From: Tim Rodway | Rodway Planning [REDACTED]
Sent: 08 October 2021 16:38
To: Tim Rodway | Rodway Planning
Subject: Fw: WA/39/18/PL - 48 The Meadows
Attachments: 03B Location & Block Plans.pdf; 02A Proposed Plans and Elevations.pdf

WA/39/18/PL - 48 The Meadows

Proposed Plans and Elevations

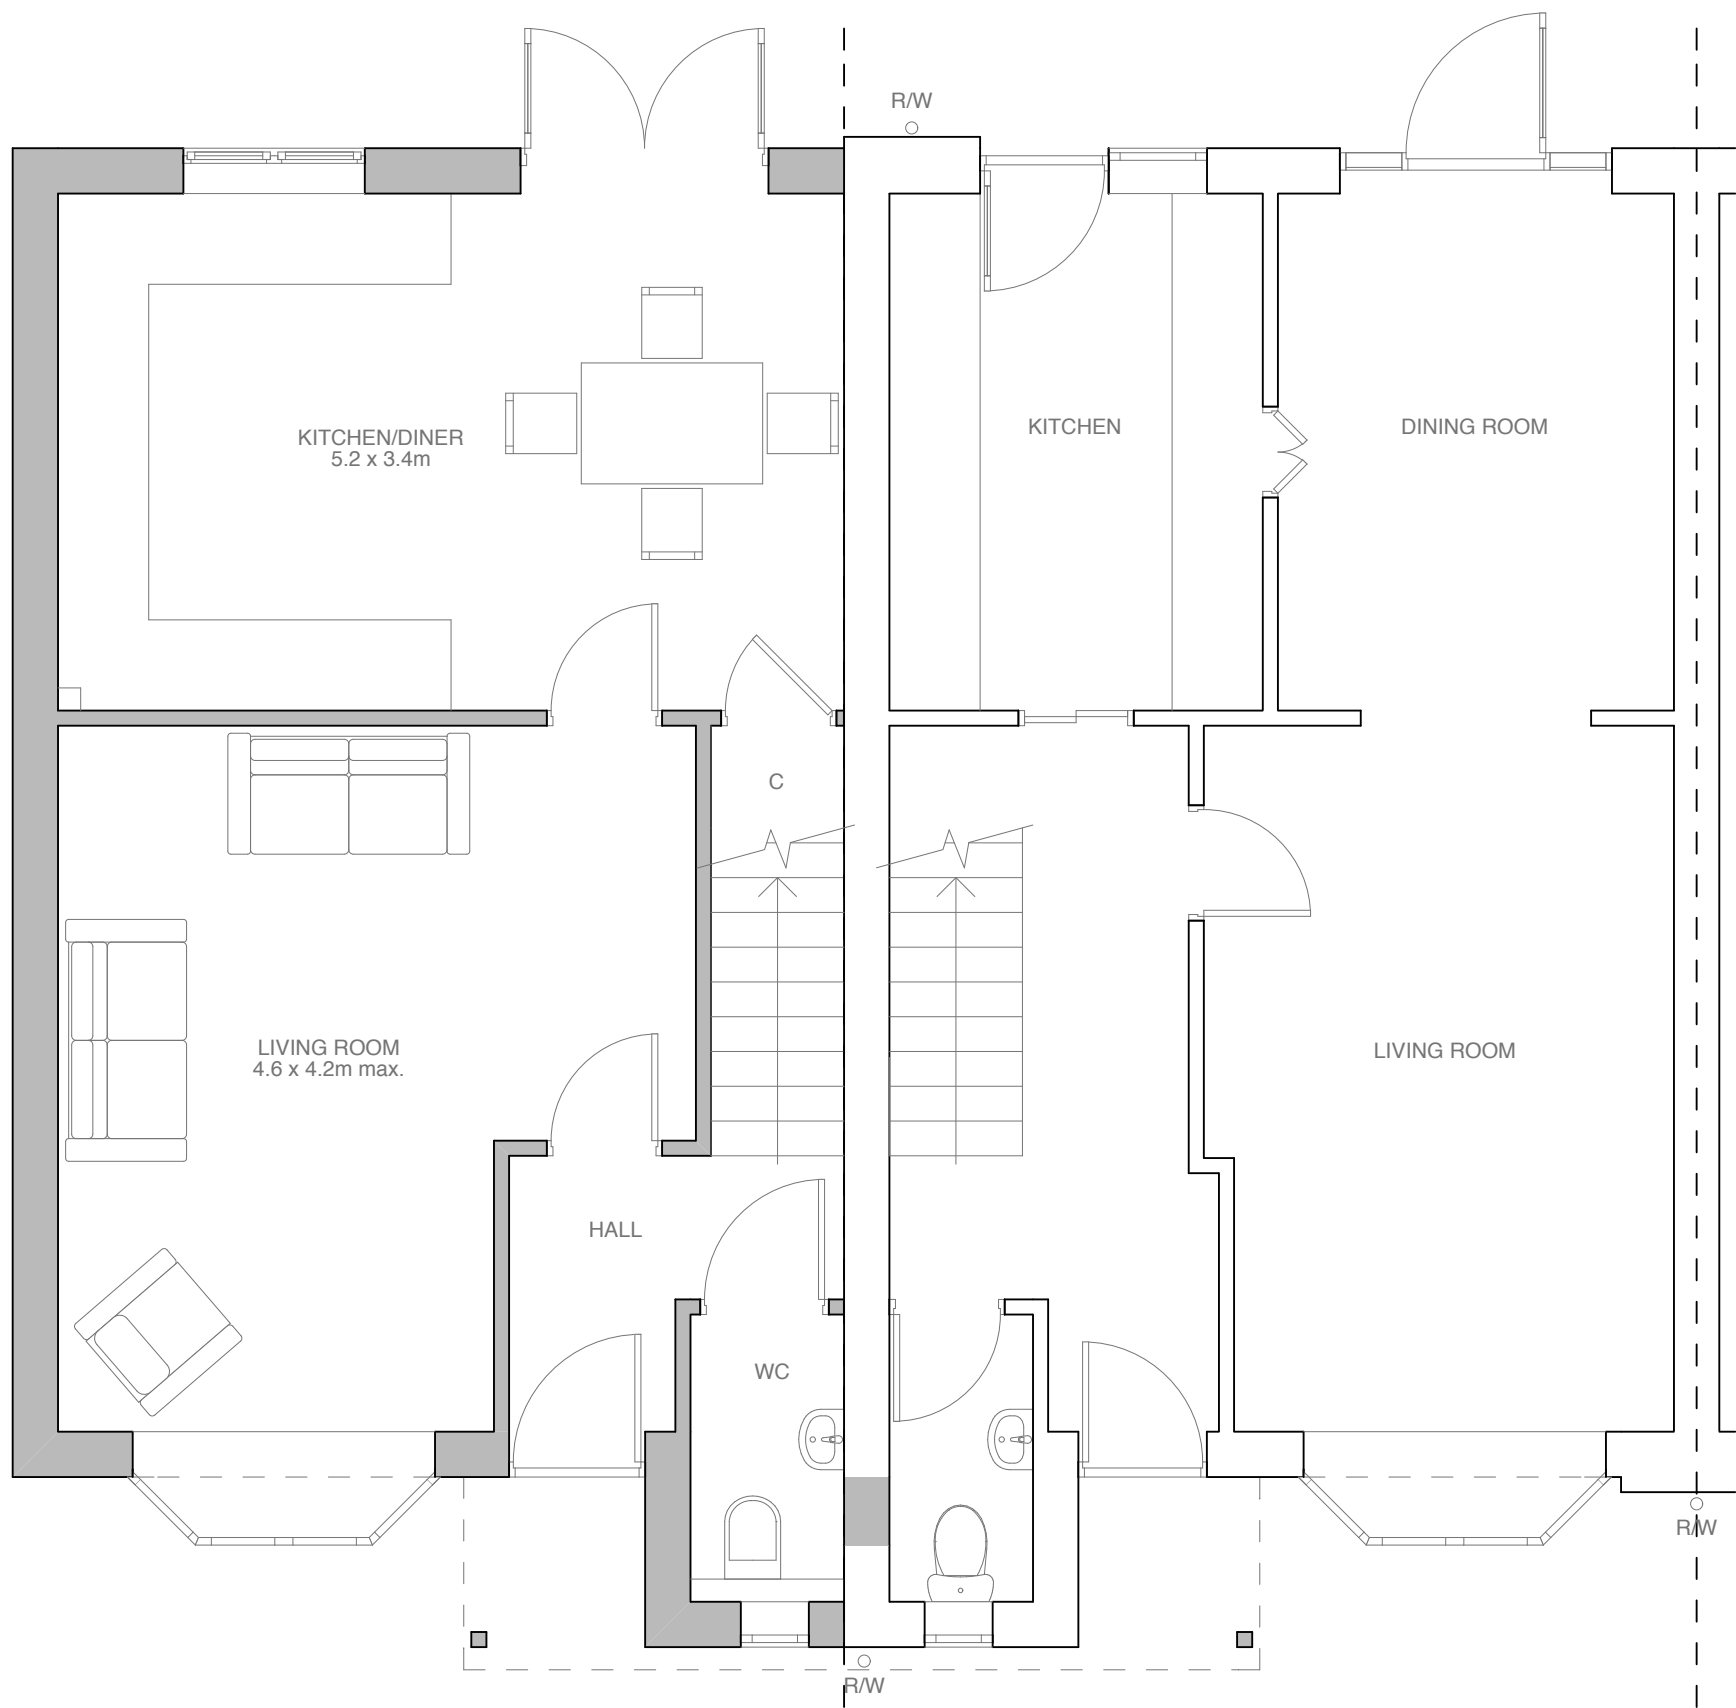
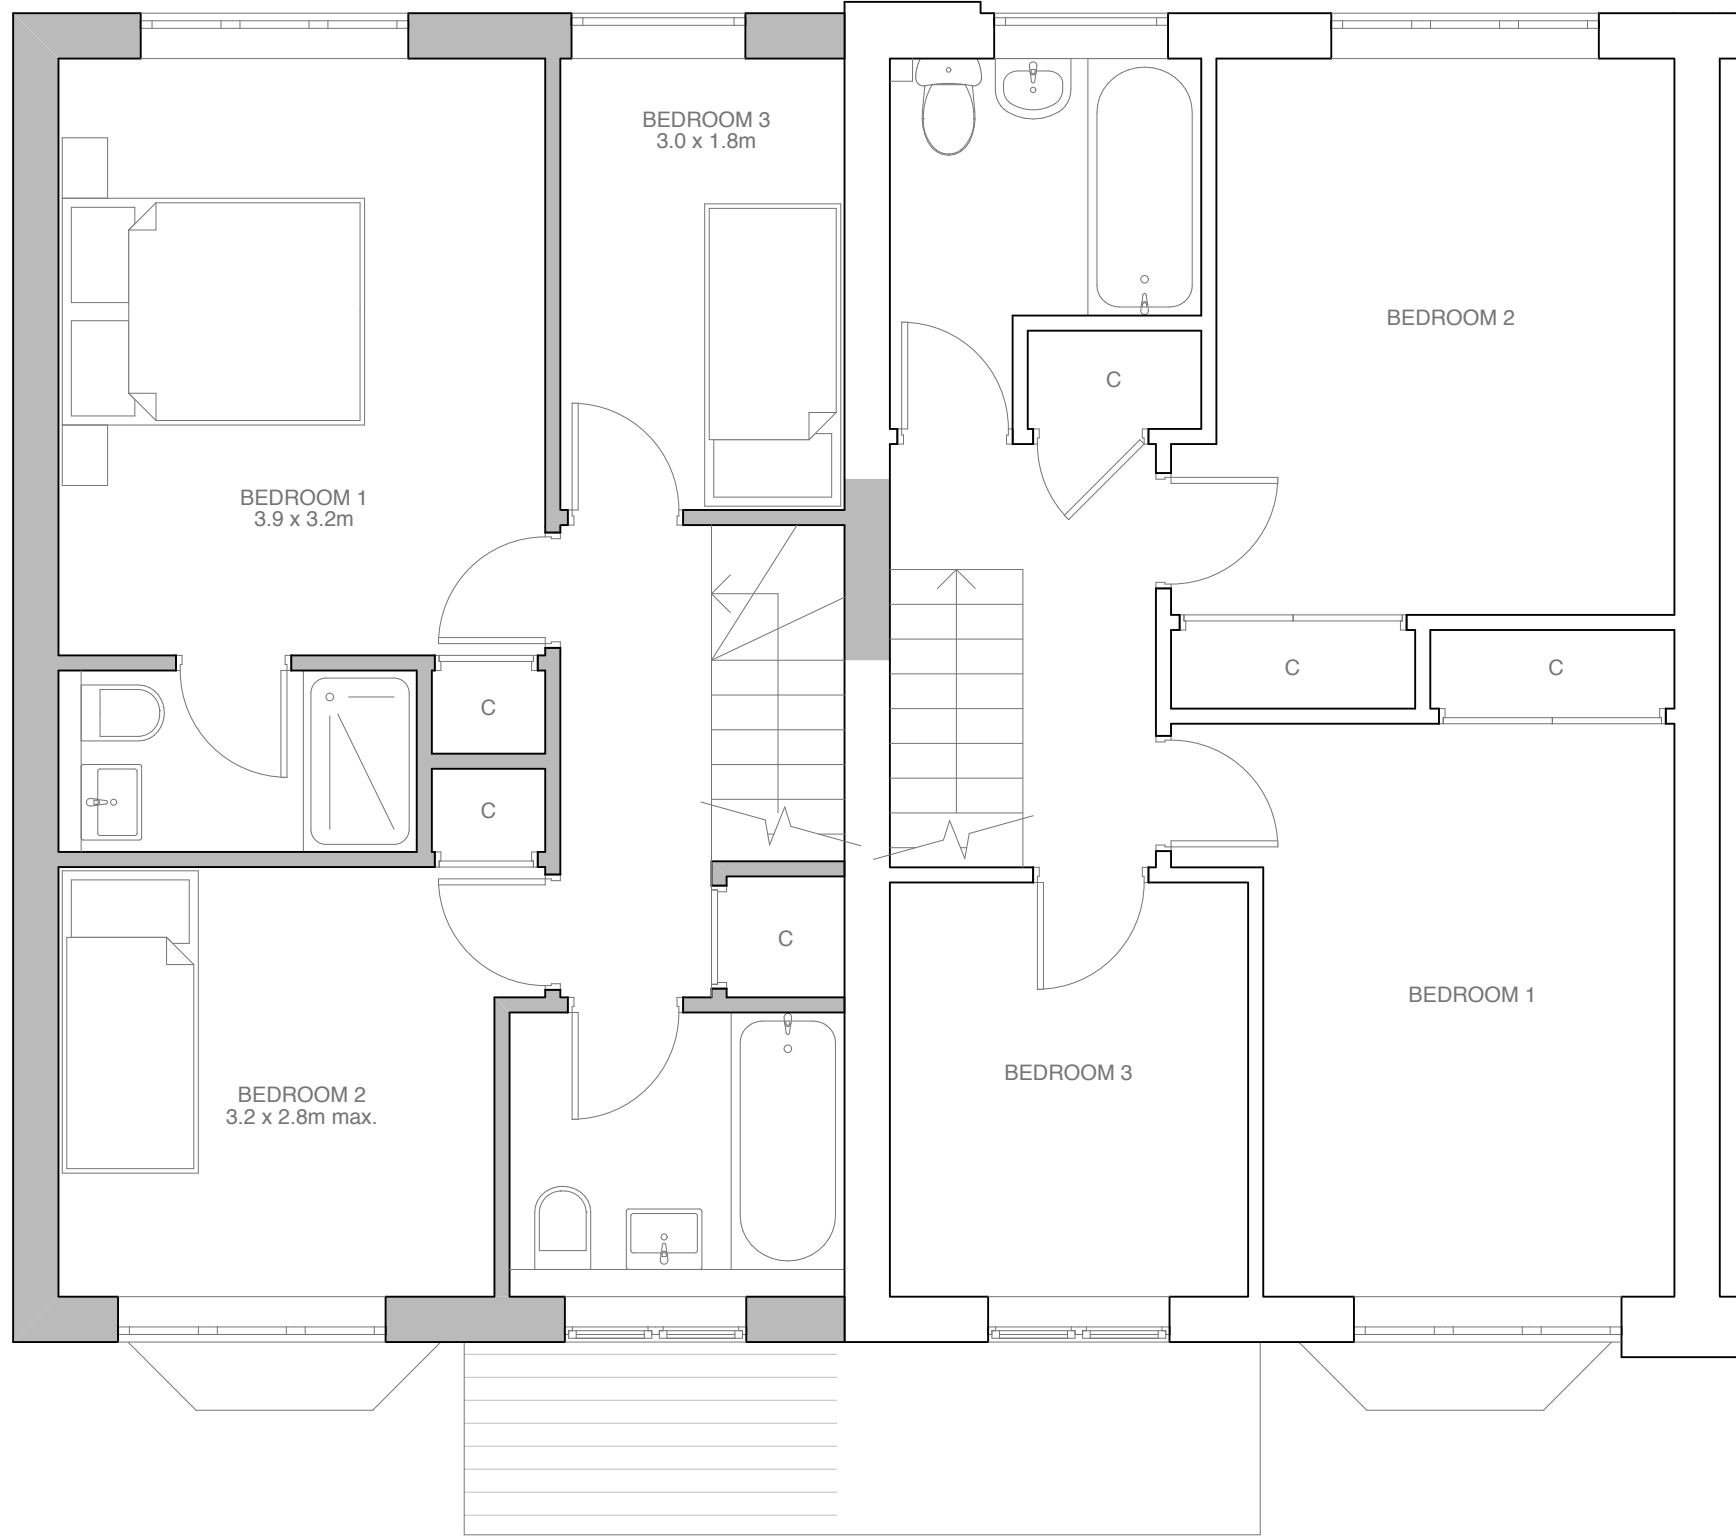
Could you provide an additional plan showing the 3 parking spaces in front of the dwelling taking into account the porches/bay windows etc. If necessary it might be acceptable to set the property back up to 70cm into to properly accommodate the parking.

My sincere apologies for the delay in issuing the attached drawings, which reflect an altered front wall position by 300mm, therefore enlarging the parking area as you have requested.

The ridge line of the roof has been slightly reduced as a consequence, but it is not felt that this minor alteration in design will upset the balance and rhythm of the terraced dwellings to which the new property will adjoin.
